Our reference: ECM: 9338762
Contact: Kate Smith
Telephone: 02 4732 7705

Response to Notification of SSD-10101987 – Request for Advice on SEAR's for the Kemps Creek Data Centre at 707-711, 713-755 & 757-769 Mamre Road, Kemps Creek

Checked By DW	Project Status SUBMISSION	
									Approved By AO	Drawing Title SITE PLAN	
									Scale 1 : 2000 @ A0	Drawing Number A010	Issue 2

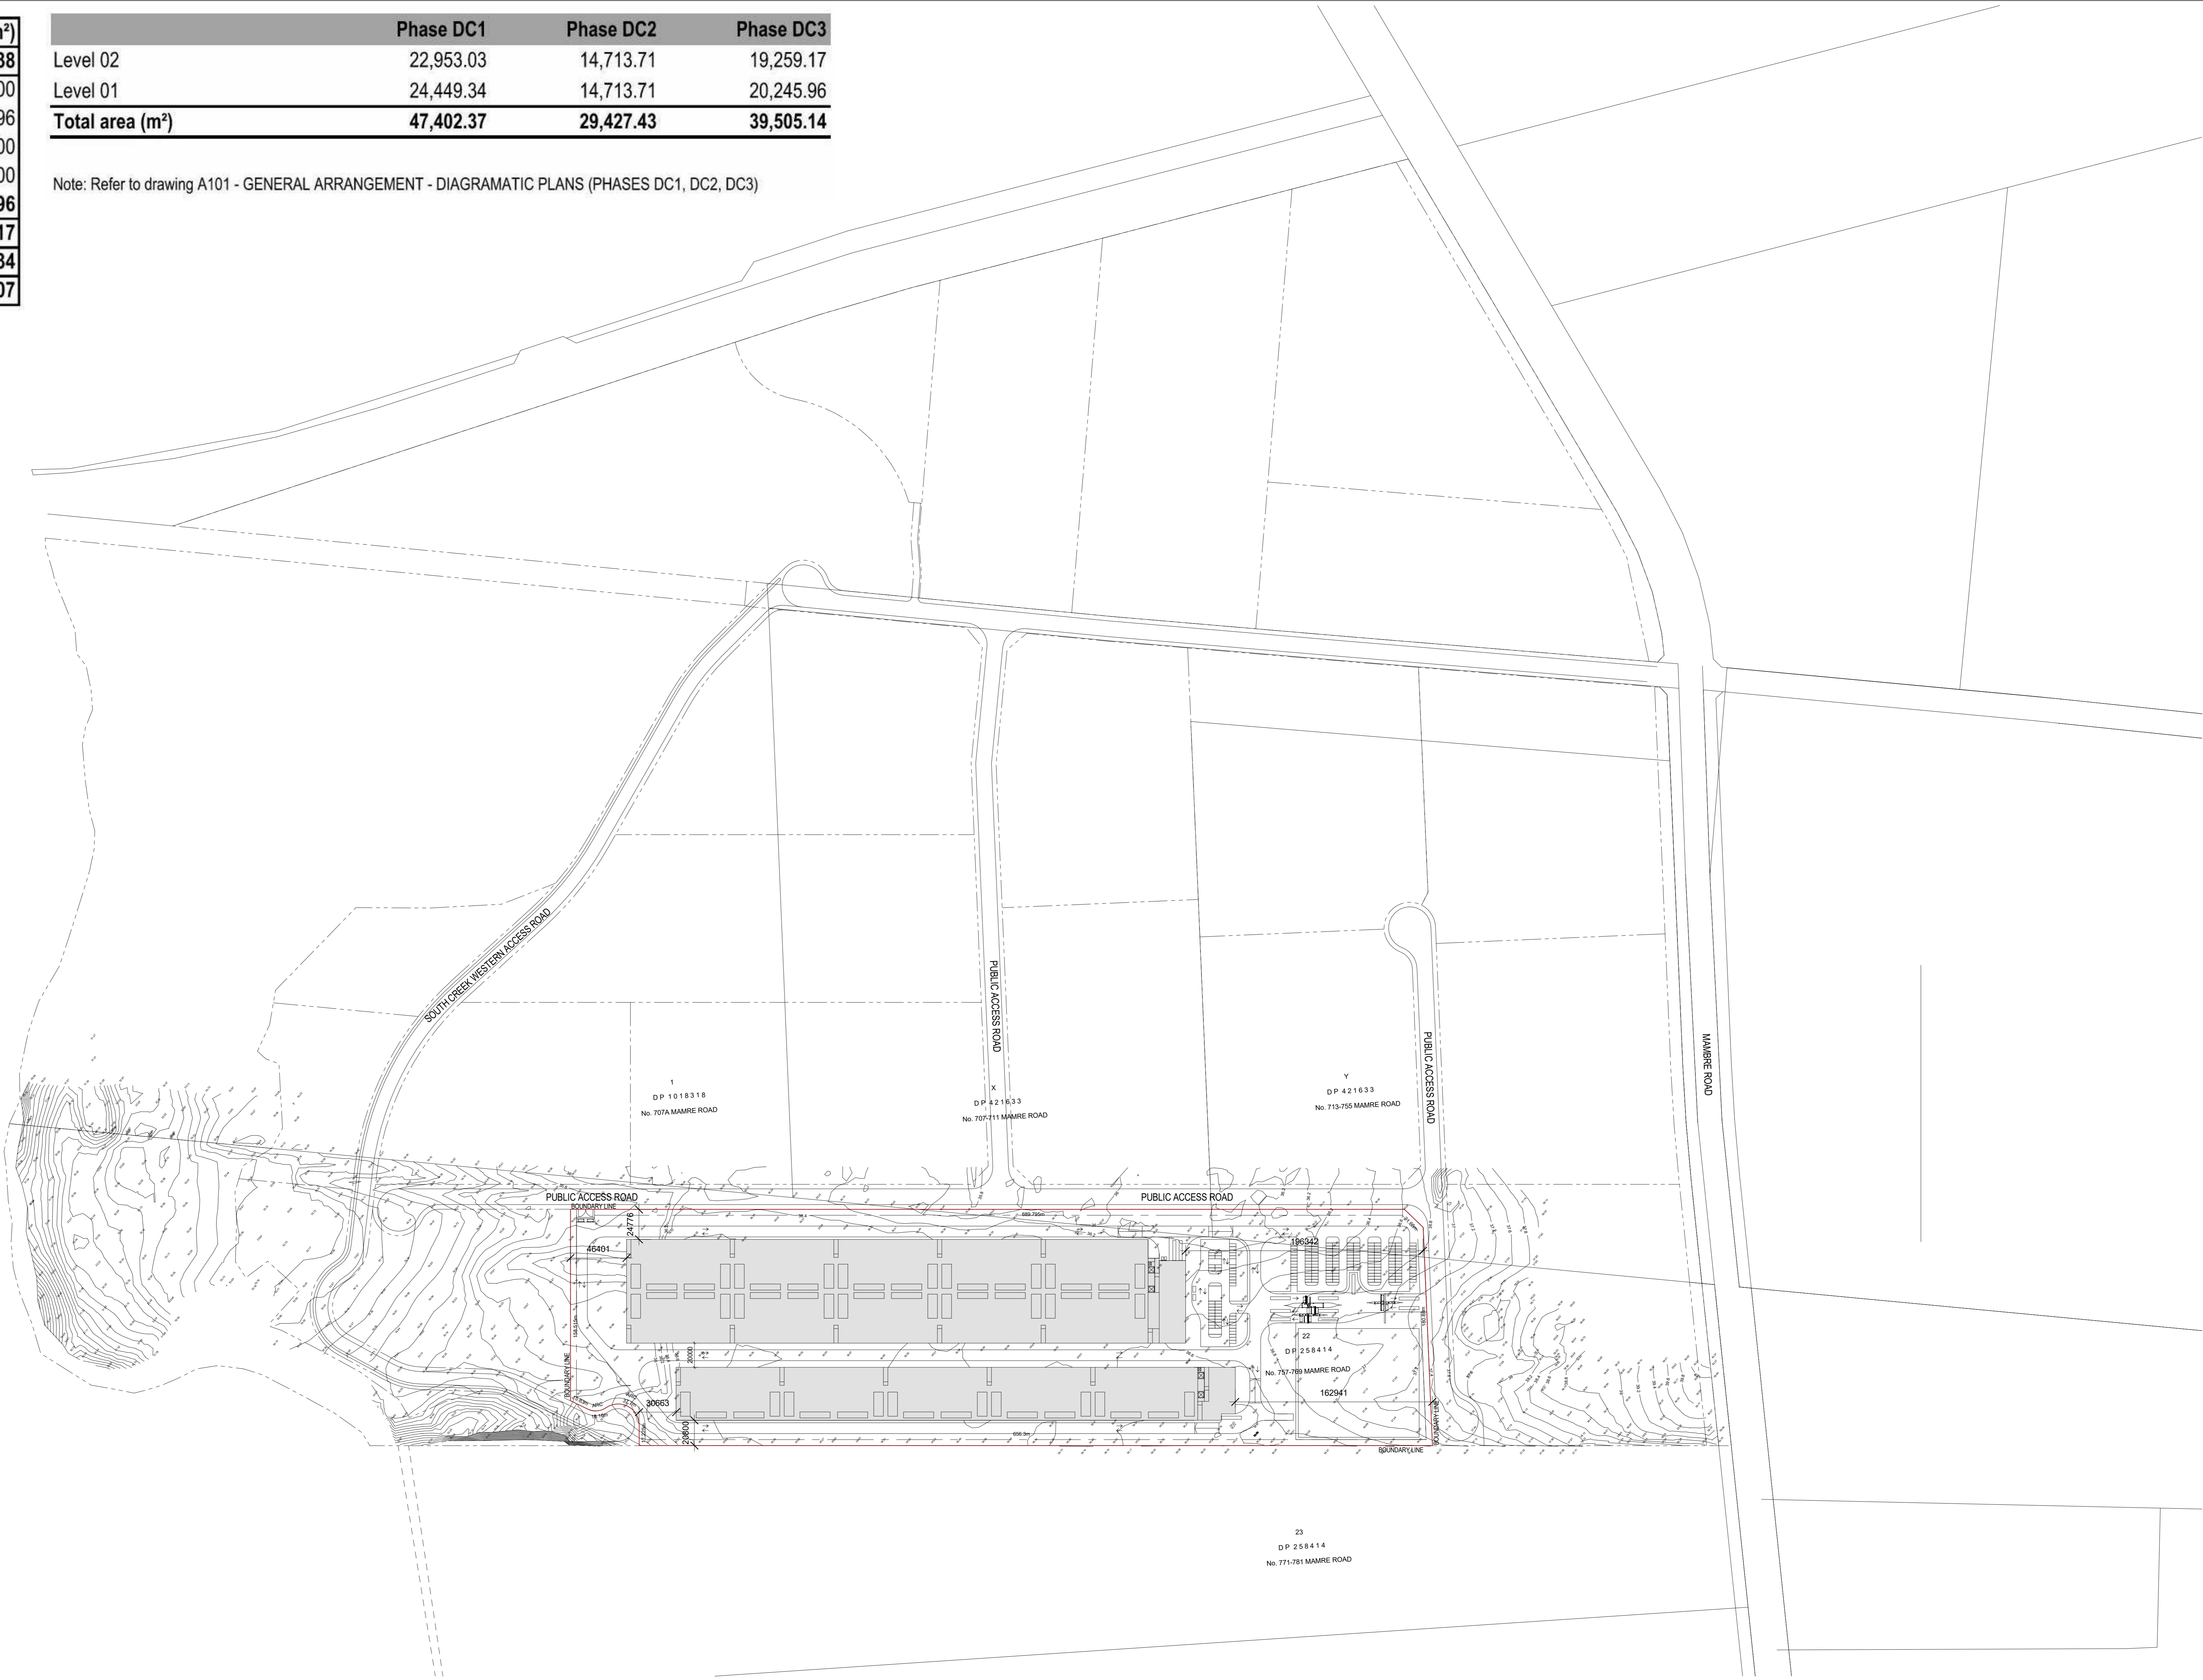
Road Design – The roads included in the proposed architectural plans do not align with those recently considered under SSD 9522. This should be reconciled, and it should be demonstrated how access to this site (the furthest site from the Mamre Road intersection) would be able to be serviced from the commencement of operations.

The finished ground levels approved in the existing SSD application for subdivision and earthworks, will dictate the need for edge treatments and suitability if landscape interface design. The architectural plans suggest a 10m southern setback from the 9m wide loop road however inadequate detail is provided of the resulting level differences between the finished pad level and the boundary / adjacent property. This is critical to ascertain if the 10m setback is sufficient, noting the 5m setback to the fence line.

The architectural plans indicated a 13m setback from the northern lot boundary to an internal perimeter road (9m wide) however only 5m is proposed between the eastern boundary and protruding car park. Council has advocated that the road arrangements in the current SSD application for subdivision be revised to negate the eastern road being the primary traffic route, preferring a linear north / south road alignment to the link road. This has not been forthcoming and as such, the setbacks to the primary traffic route are critical as the setbacks should reflect those to a typical collector road and not a local street.

The 13 parking spaces protruding into the eastern setback should be deleted to allow for an unencumbered 10m landscape setback, not dissimilar to what is proposed to the northern boundary.

Further the HV Switch Yard should also be amended to provide a continuation of the 10m setback line given the abundance and exposure of the hard stand area visible from both the public domain and what will be a significant transport corridor. There also appears to be ample internal space that allows for the relocation of the switch yard to the west, without compromising the available space of the yard.

Drawing Title  
ELEVATIONS - SYD05-06

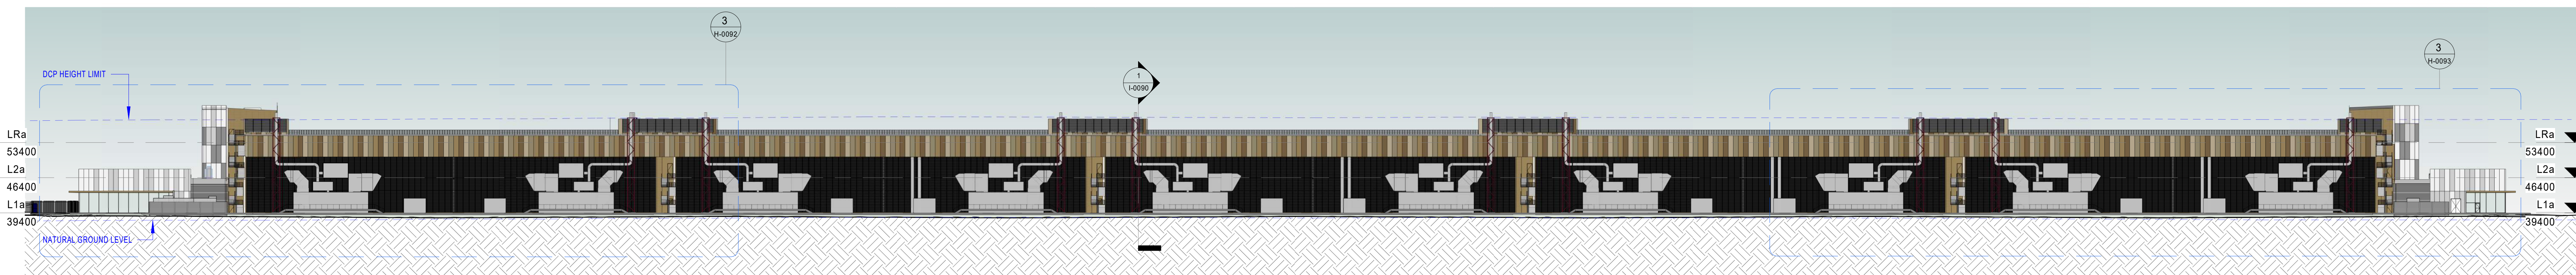
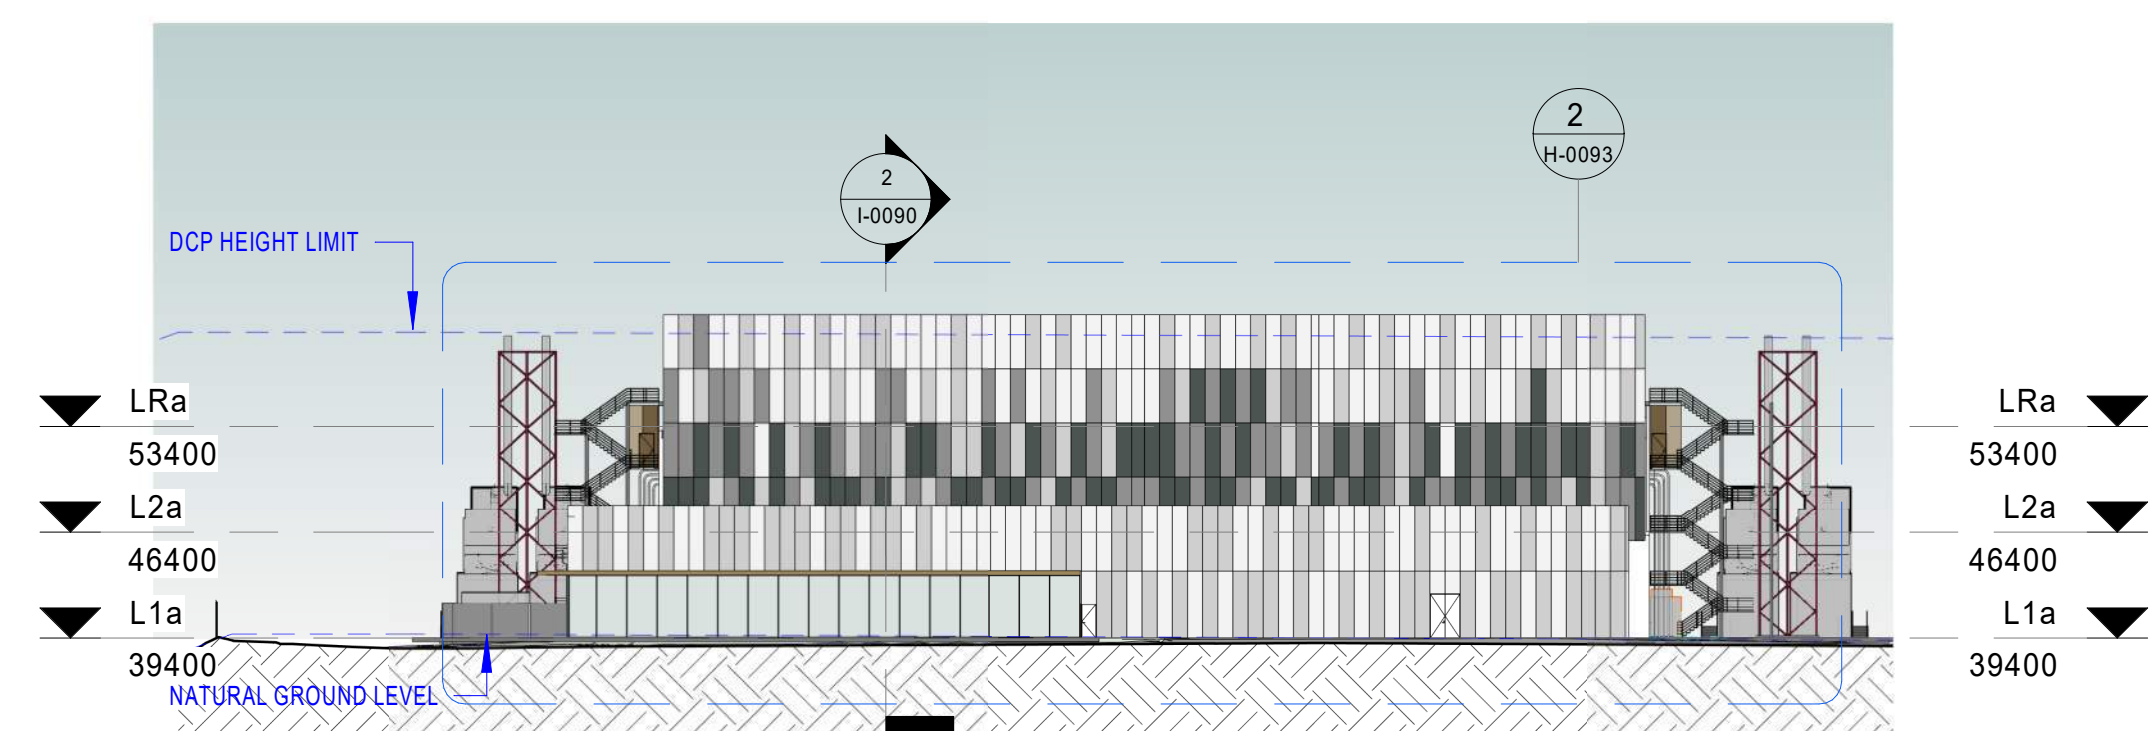
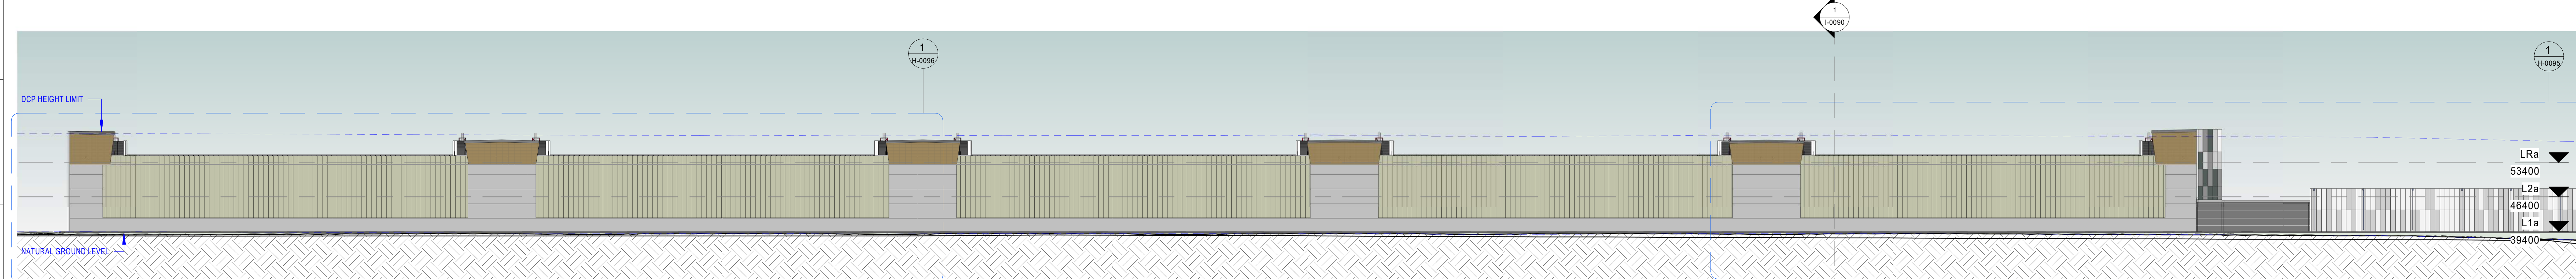
Visual Bulk and Scale – The site comprises two very long buildings, which are not visually broken up and therefore have potential for significant visual impacts. An assessment of this visual bulk from various surrounding points, including Wianamatta-South Creek, existing residential communities to the west and north, as well as Mt Vernon to the south should be undertaken as part of any future DA.

Design Quality – Consideration should be given to focusing visually interesting elements to the building, such as through articulation, use of materials or similar. The building arrangement and architectural form provides elongated buildings with little design treatments are articulation elements as viewed from the street. Appreciating the use is a data centre, embellishment into the architectural form should be encouraged to ameliorate the overall mass and repetition of the building as viewed from the streetscape. This may not mean the footprint is amended but the elevation form and materiality mix should be further considered.
